Rezoning Transportation Analysis

Petition Number: 2021-082

Date	Description
08-02-2021	First Review (DBS)

RZ-1.0

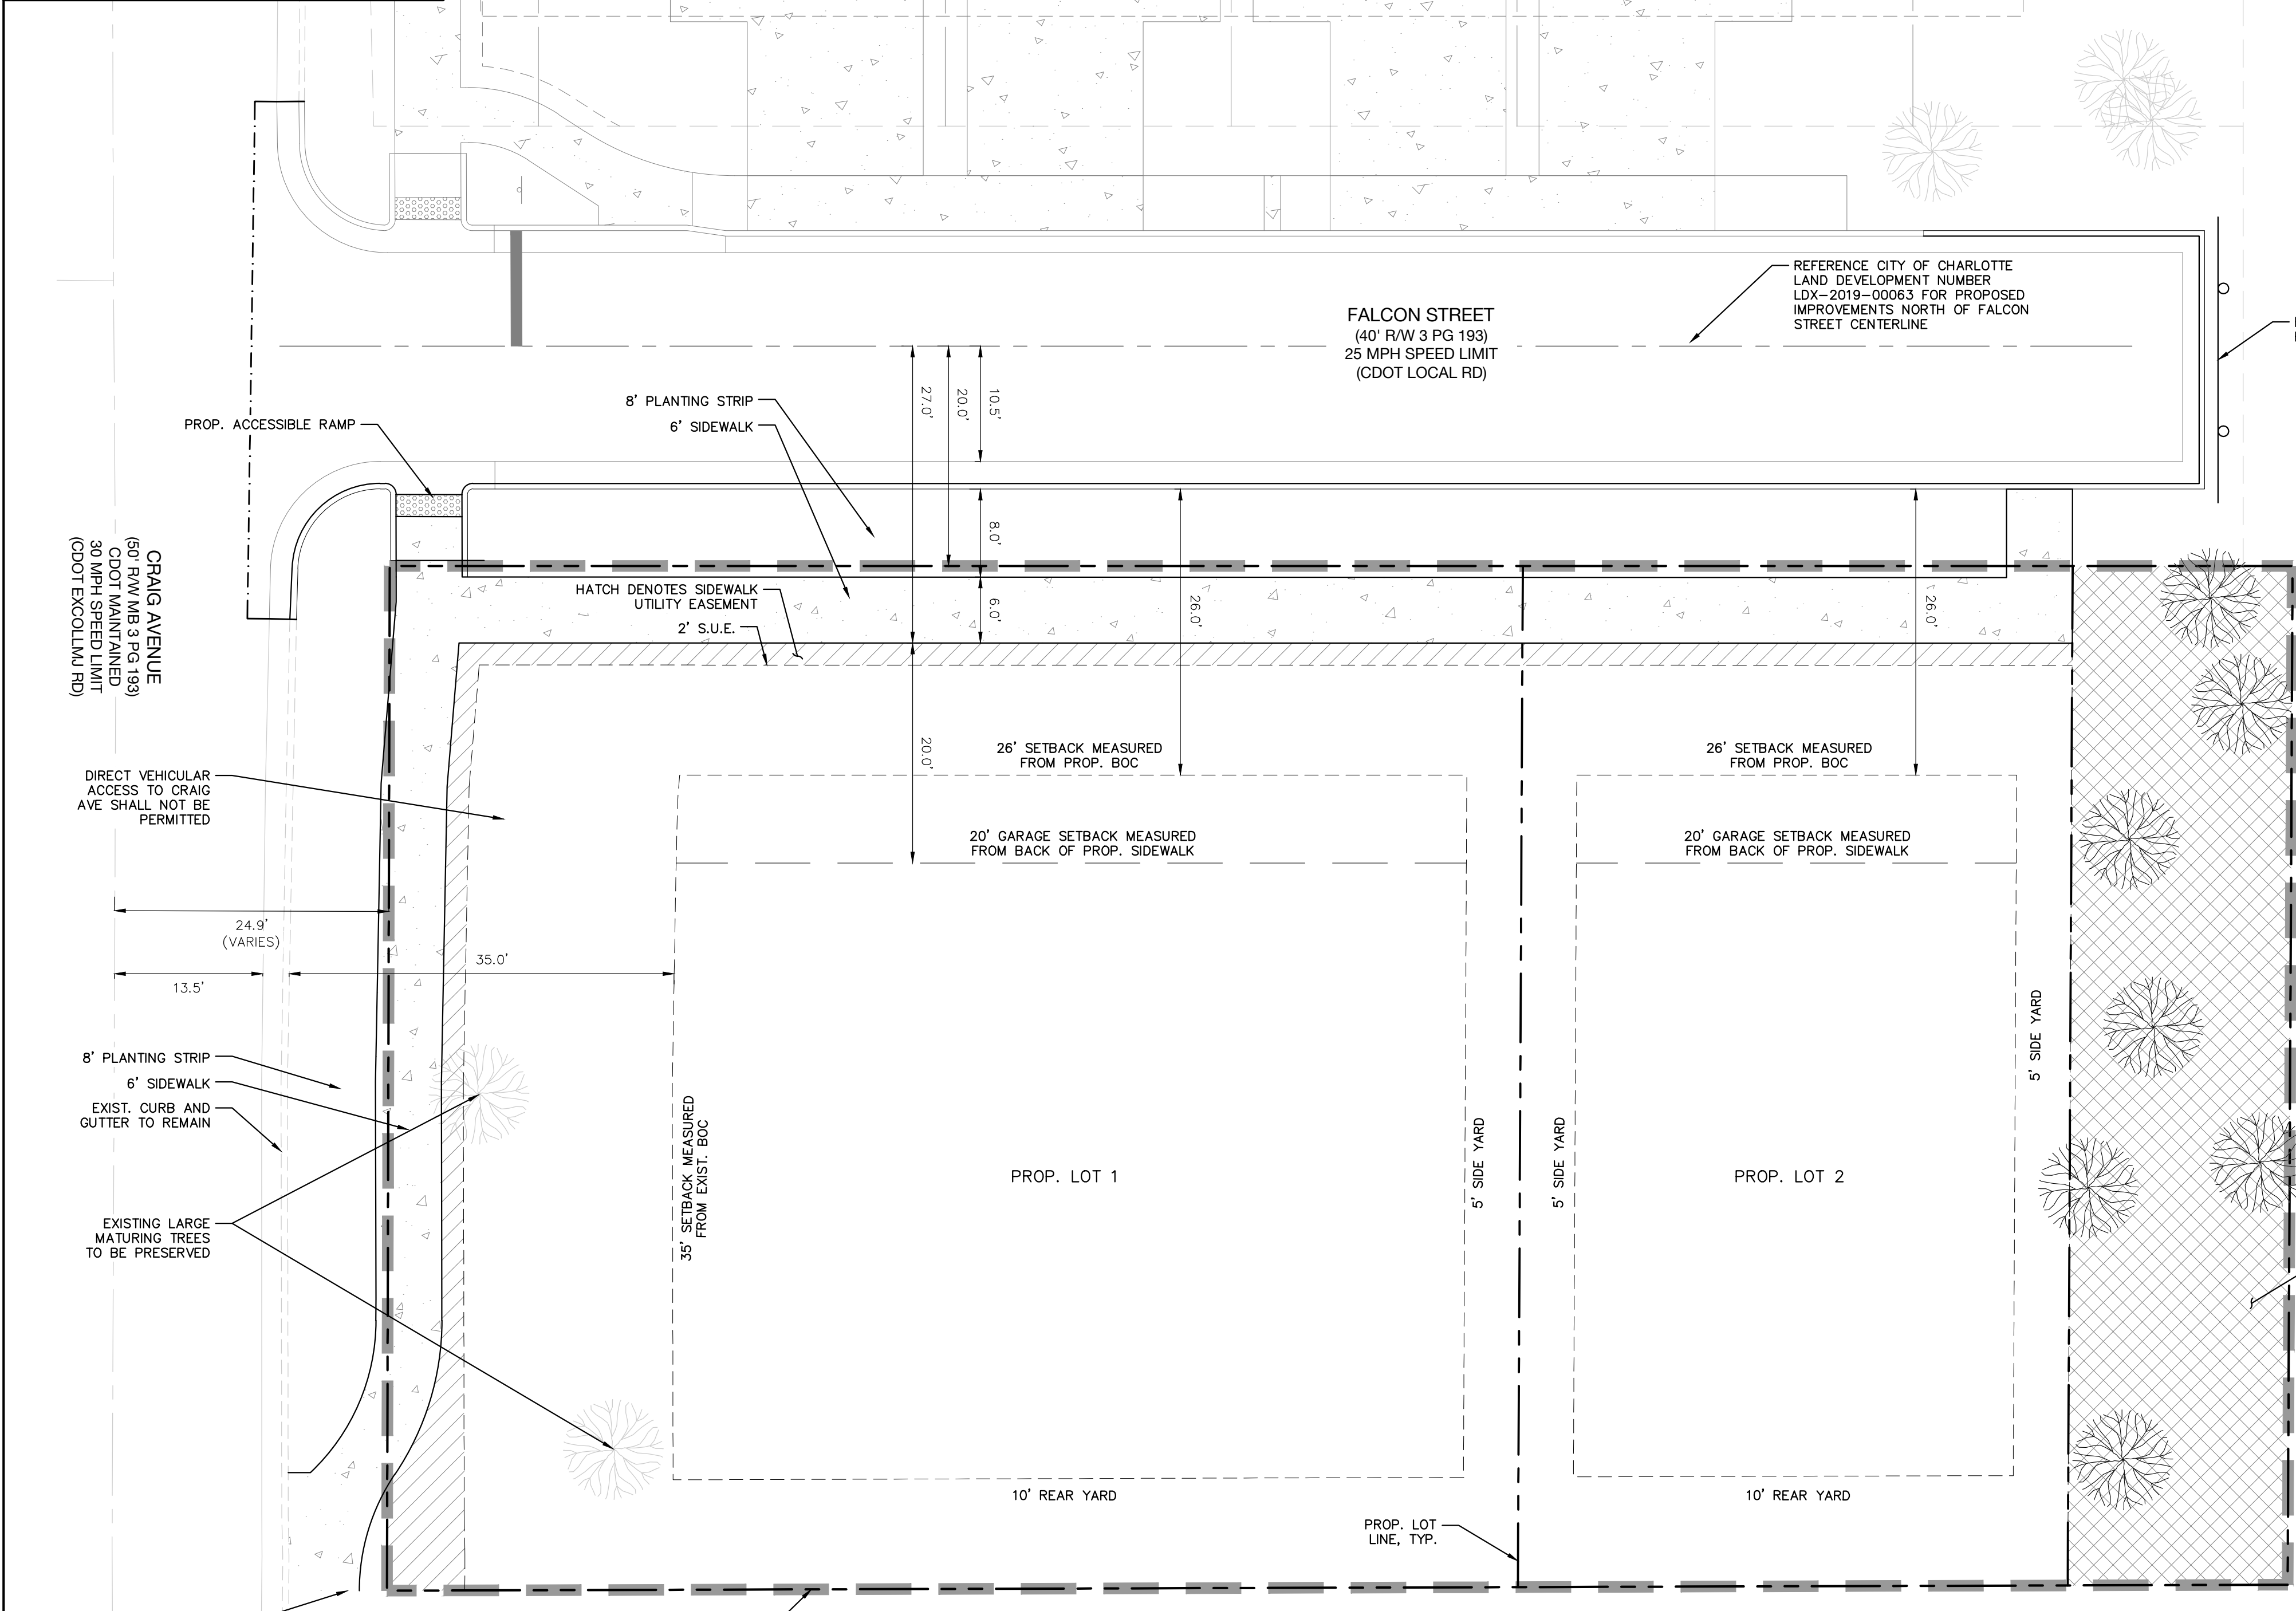
The site is located adjacent to Craig Avenue, a City-maintained major collector near the intersection of Craig Avenue and Falcon Street, an unopened public right-of-way. A Traffic Impact Study (TIS) is not needed for this site. Site plan revisions are needed to meet ordinance requirements and the outstanding items include, but are not limited to, extending the Falcon Street stub to the eastern property line. Further details are listed below.

1. A Traffic Impact Study (TIS) is not necessary for the complete review of this petition due to the site generating less than 2,500 daily trips. If during the permitting process the site generates more than 2,500 daily trips, then a traffic study will be required.
2. Revise site plan note that Falcon Street is City-maintained. Although it appears to be public right-of-way, it is not currently City-maintained.
3. The residential narrow street type is not valid for this density. Revise site plan accordingly.
4. Revise site plan to reflect the Falcon Street stub extending all the way to the eastern property line.
